PLAN REVIEW SHEET

Petition #: RZP 2022-118

Address: 8835 Harrisburg Rd.

Request: MX-1, B-2

8835 HARRISBURG RD CHARLOTTE NC 28215
REZONING

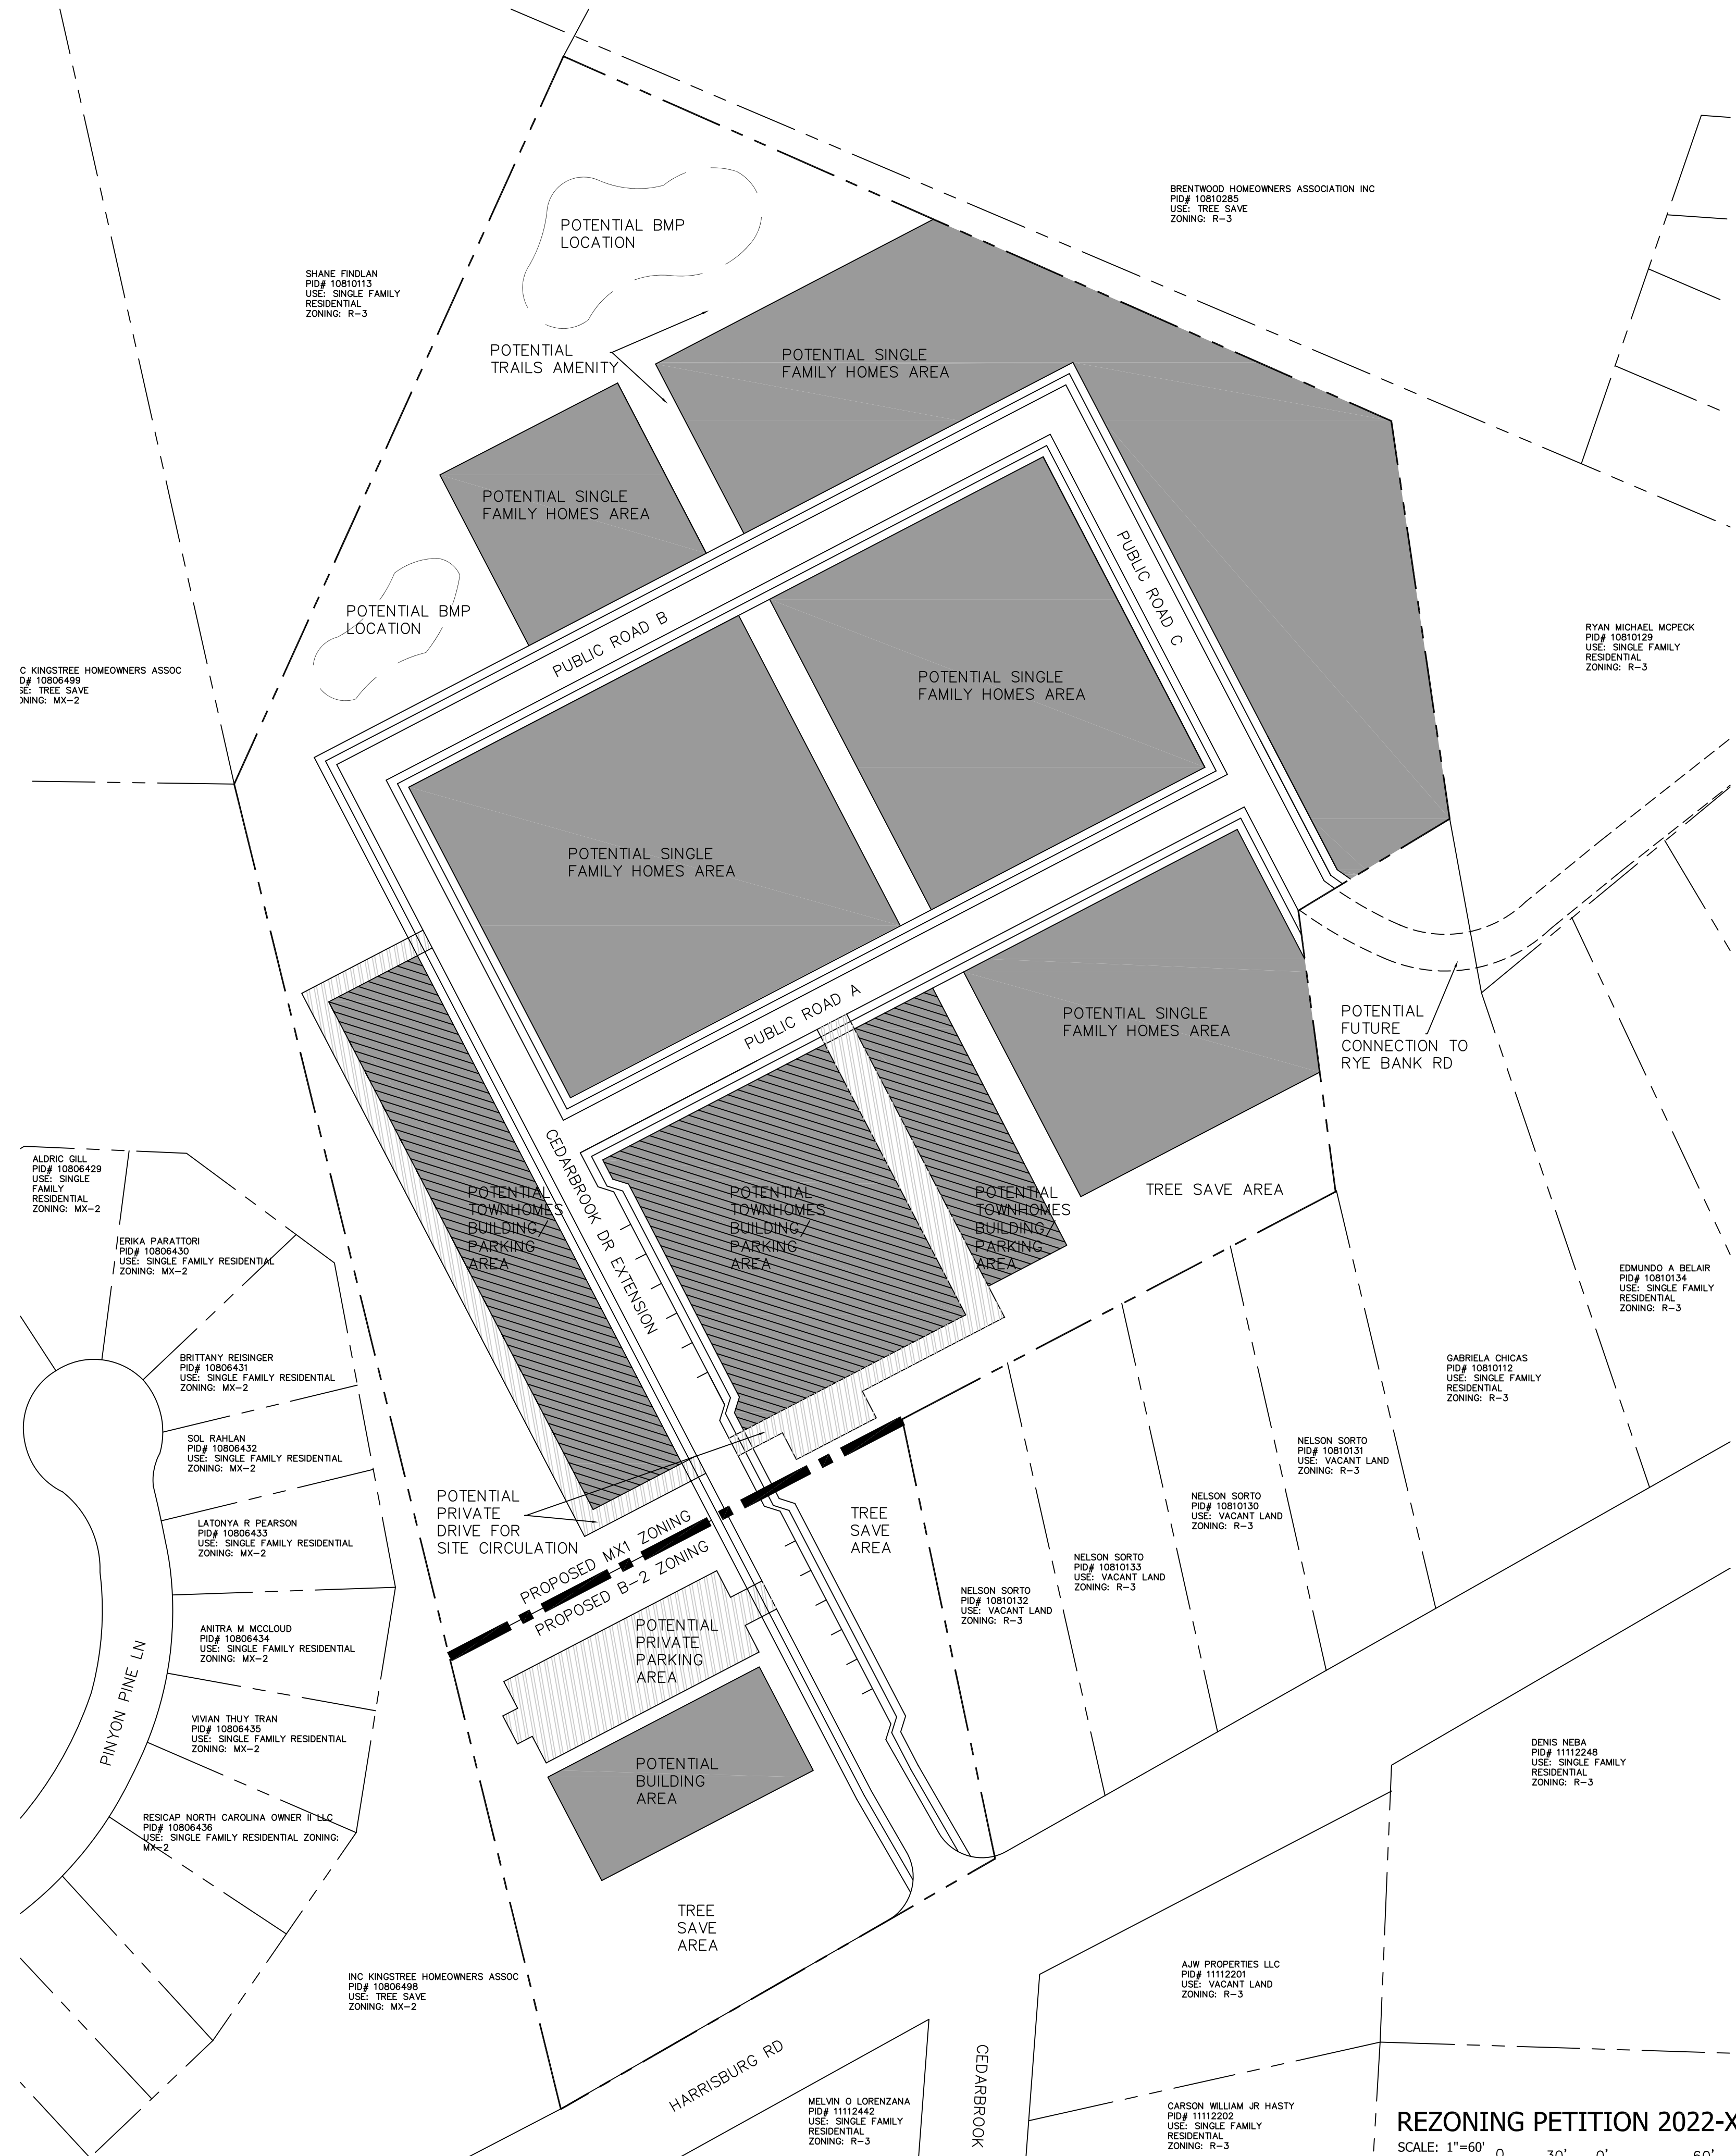
The site is located on CATS local express bus route #46x along Harrisburg Road. CATS requests the relocation of this stop and construction of ADA compliant bus stop type 60.01A. The final location will be determined during the Land Development plan review process.
